Your Ref: OWPC17013
Our Ref: LU/386/17/PL 17-11-2017
Please ask for:
Ross Leal

Change of use of land for the stationing of 14 No. mobile homes for permanent residential occupation. This application is a Departure from the Development Plan.

Land to East of Torri House Old Mead Road Littlehampton

Site Plan	
Date	November 2017
Scale	1 : 500 @ A3
Sheet	MJS/11-2017/ PL47-02

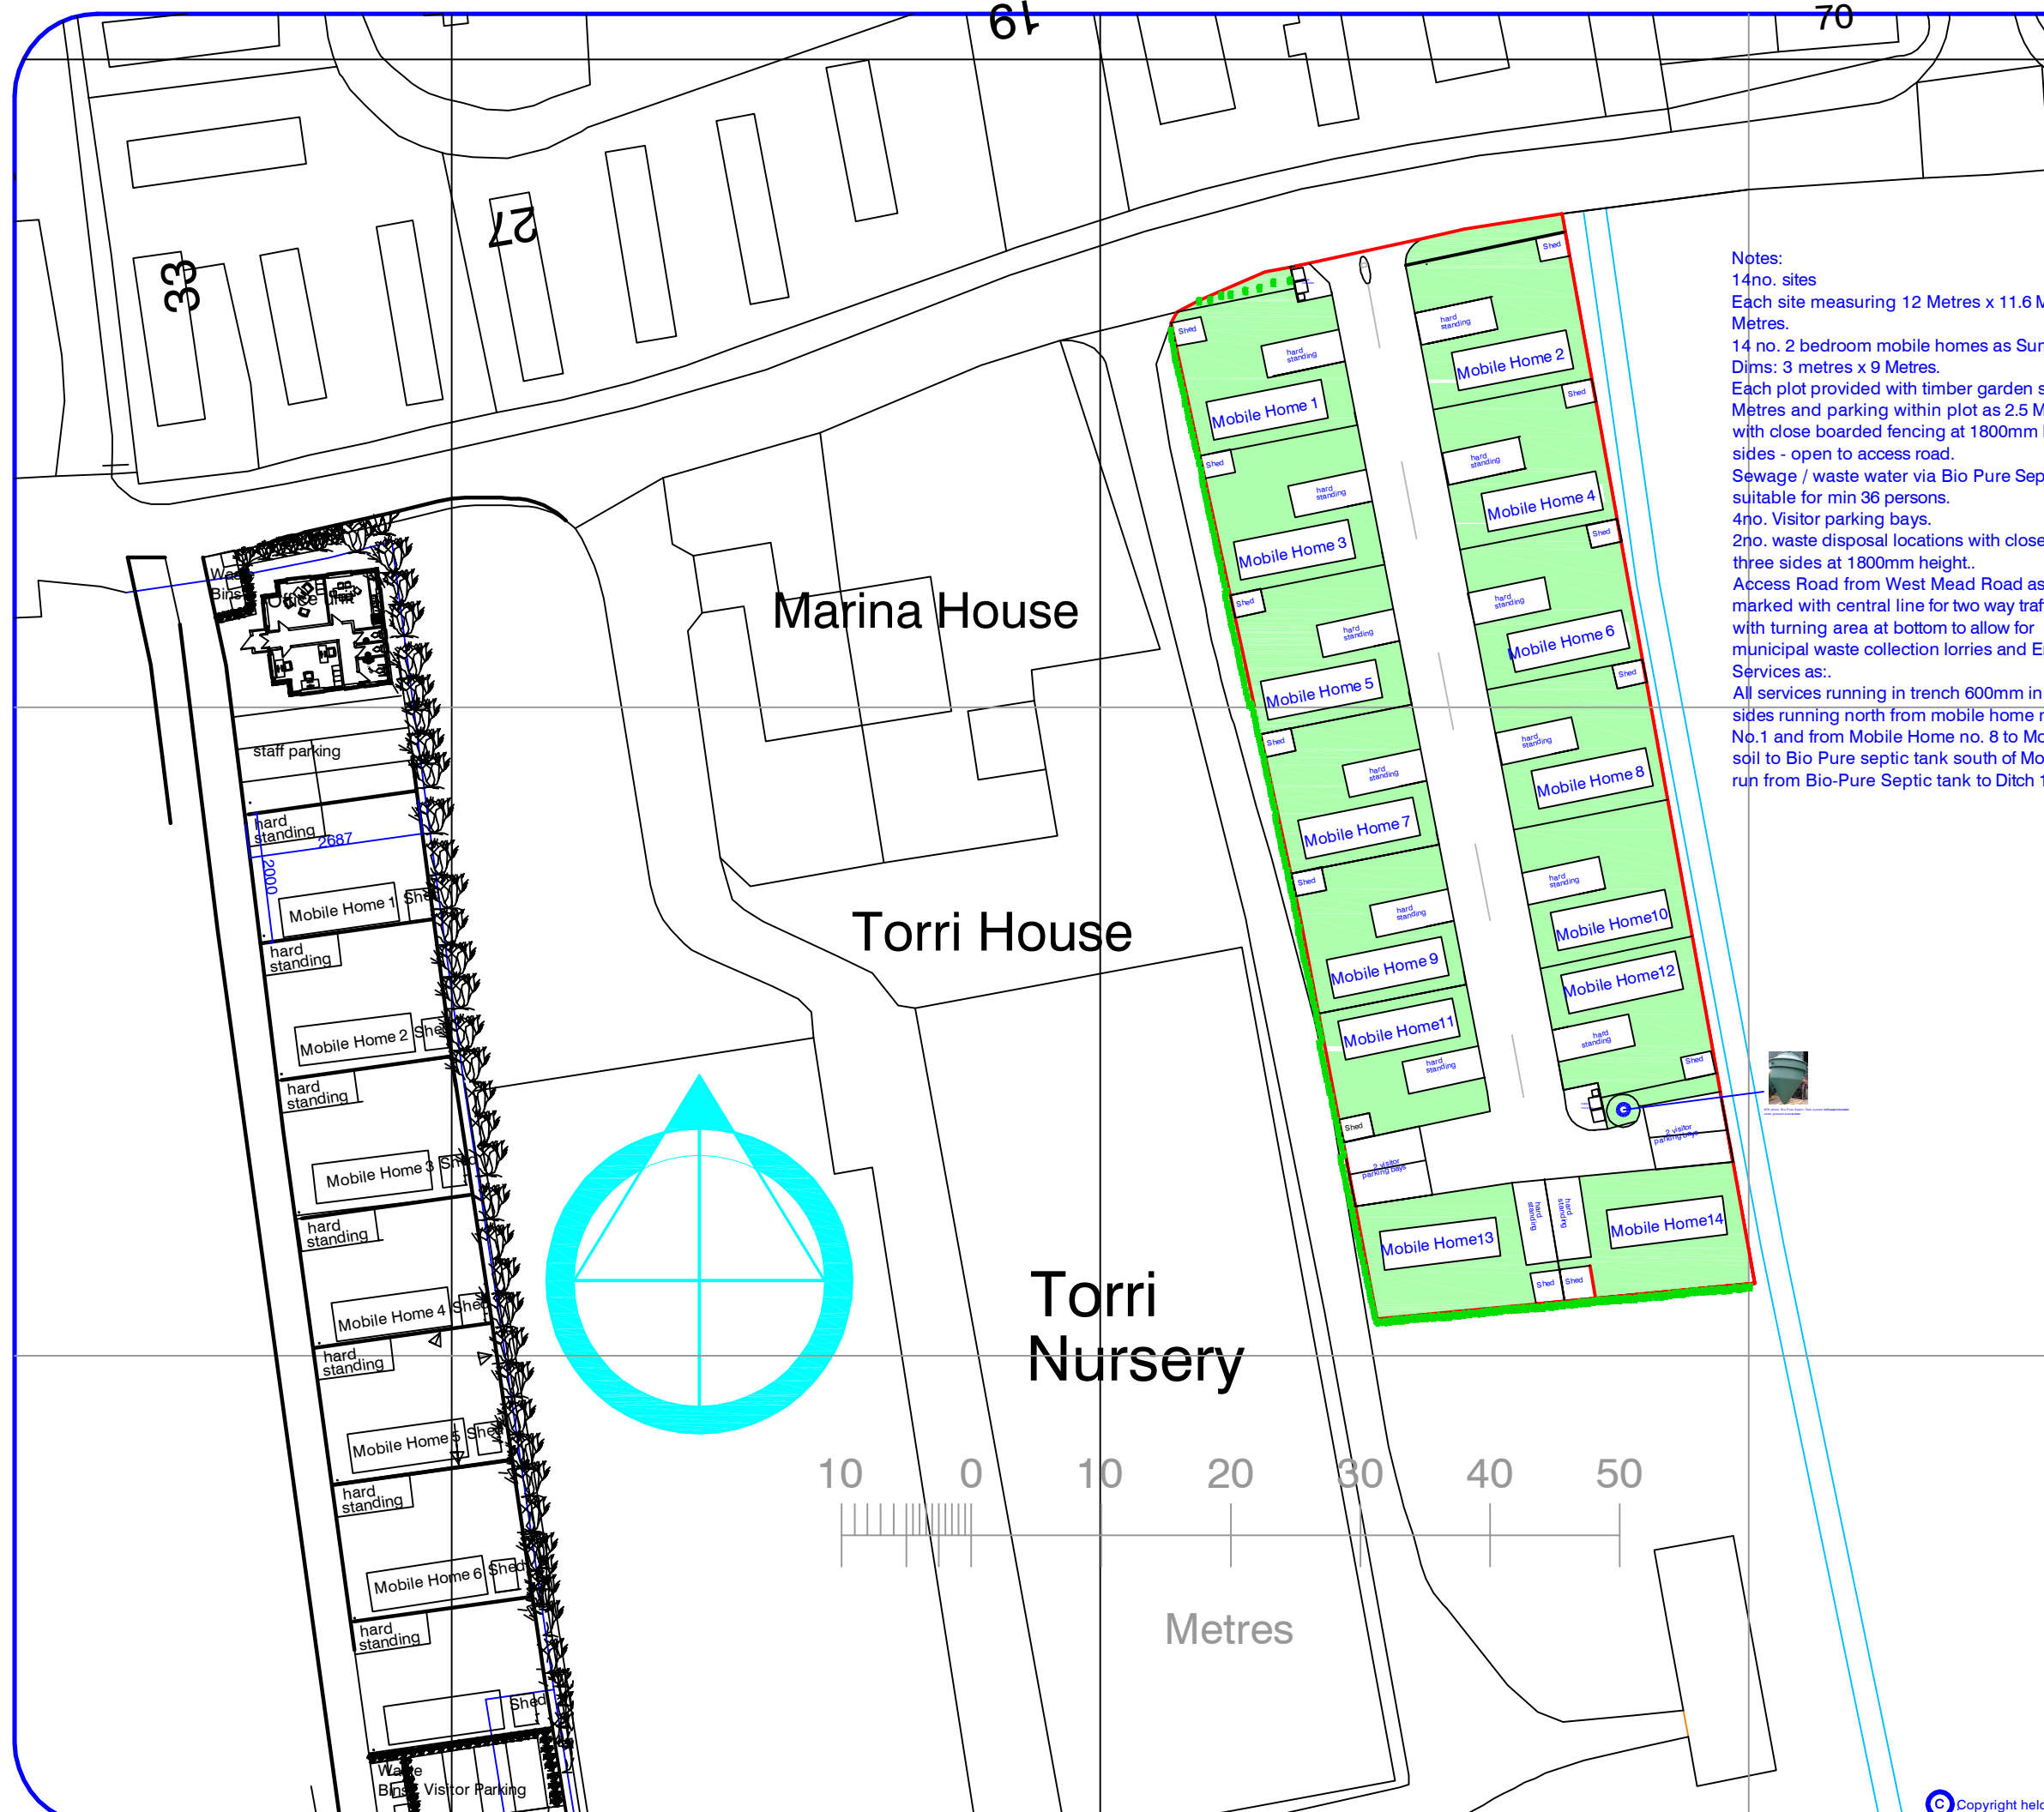
Old Mead Road is in a flood area and the rain run off from roofs, road and paths will only increase

the risk as there is nowhere for this extra water to go. I know from my own garden how high the water table is even in the summer, how wet it gets with standing water on the grass, paths and outside in the road, I don't see any drains in this road to take rain.

The road will see a lot more cars which it wasn't designed for and parking will be limited on the site, where will all the other cars go?

I don't think the sewers in this road can take the extra waste and give trouble already to those homes on the sewer system. Southern water still seem to get confused by the sewer system in this road, not knowing which homes are on it and which are not.
